Rezoning Transportation Analysis

Petition Number: 2023-046

Date	Description
08-25-23	First Review (NK)

SCHEMATIC SITE PLAN

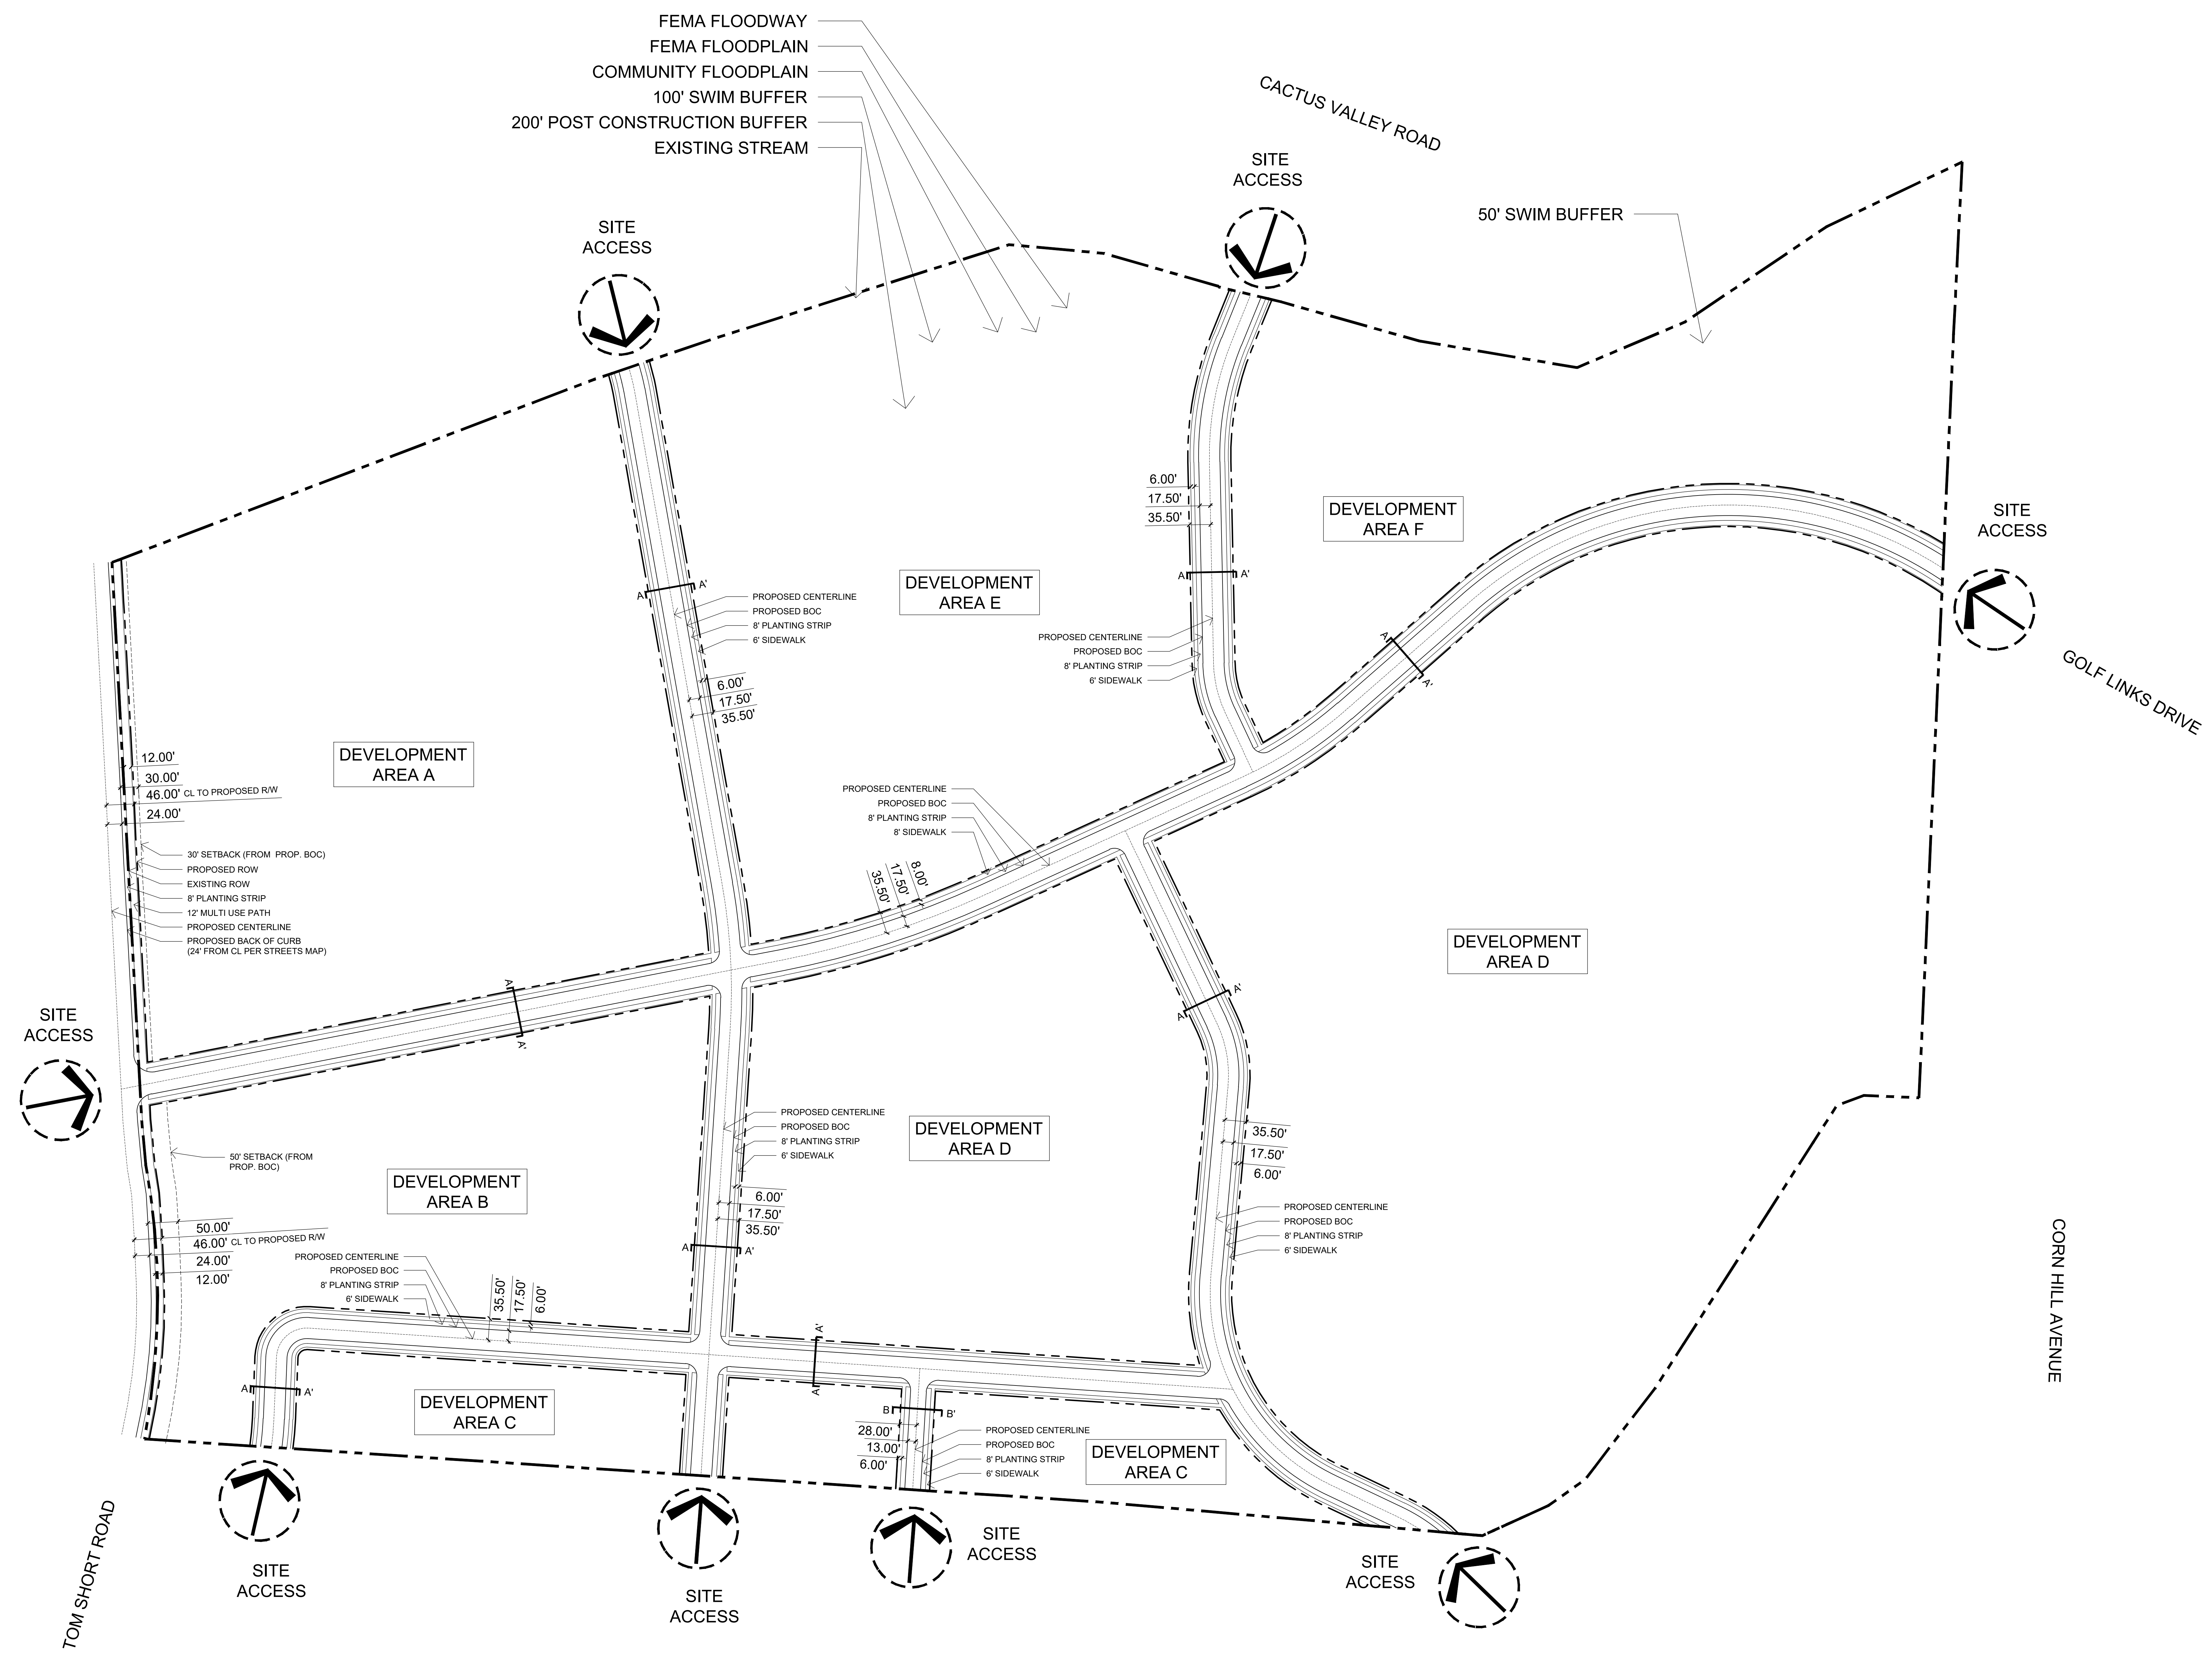
Tom Short Road: Location of back of curb and gutter to be moved to 24' feet from roadway centerline to accommodate the Charlotte Streets Map with a roadway typical section of 2+ Avenue, Bike Lanes.

Label and dimension the curb and gutter from the centerline for each road on the site plan.

3. Revise site plan and conditional note(s) to commit to dedicate 46' right-of-way from the road centerline. The site plan shall label and dimension the right-of-way from the road centerline.

7. Remove this intersection, and ensure all future horizontal curves meet the minimum CDOT standard of 150' radius.

8. Align internal public roads to remove offset intersections.

9. The horizontal curves pictured below need to have a minimum 50' separation to meet minimum CDOT standard.
